SOUTH HOLLAND DISTRICT COUNCIL

Purpose: To consider Planning Application H23-0534-23

Description: Erection of 37 dwellings including road layout, scale, appearance and landscaping - outline approval H23-0827-22

Location: Land North of First Bungalow Stockwell Gate Whaplode

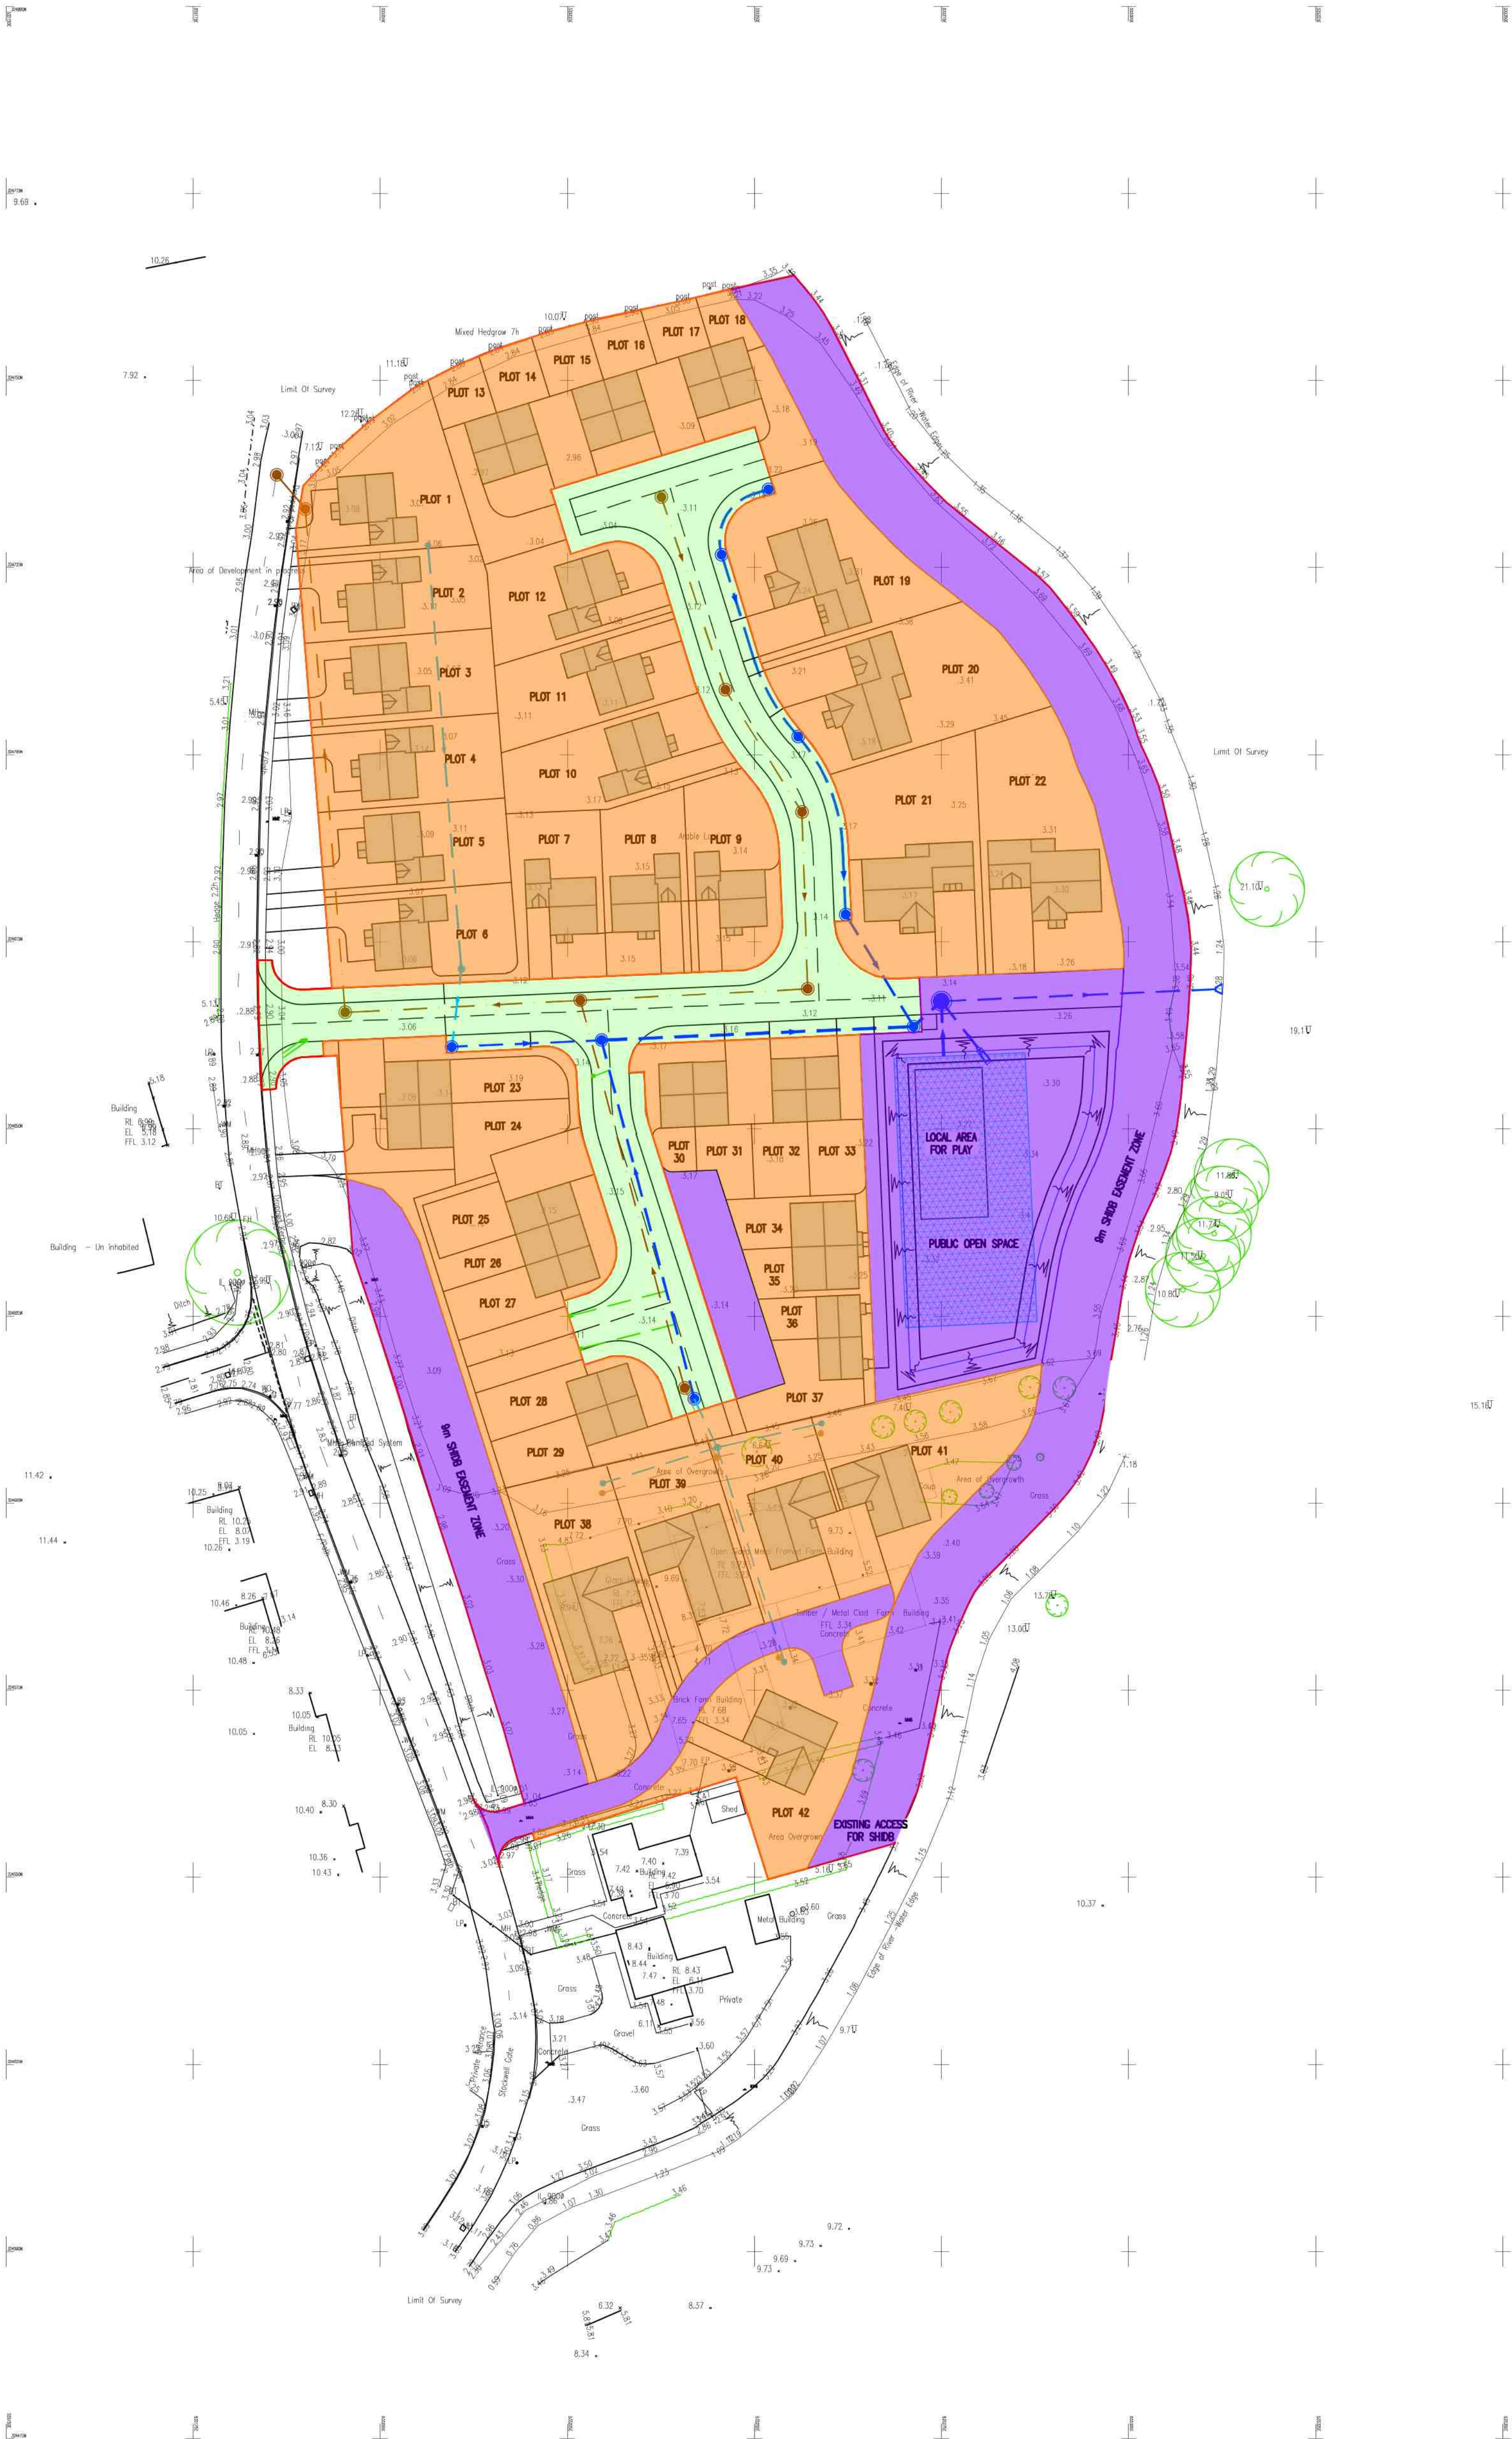
6.37 The amendments do not include the roadside filter drains that were shown on the Approved Plans of the Outline Consent.

6.38 No additional drainage information has been submitted with this Reserved Matters Application so it is presumed that the Applicant is expecting to rely on the drainage strategy approved under the Outline Consent H23-0827-22. If so, then I am not able to clear this Reserved Matters Application with footways where there are supposed to be filter drains.
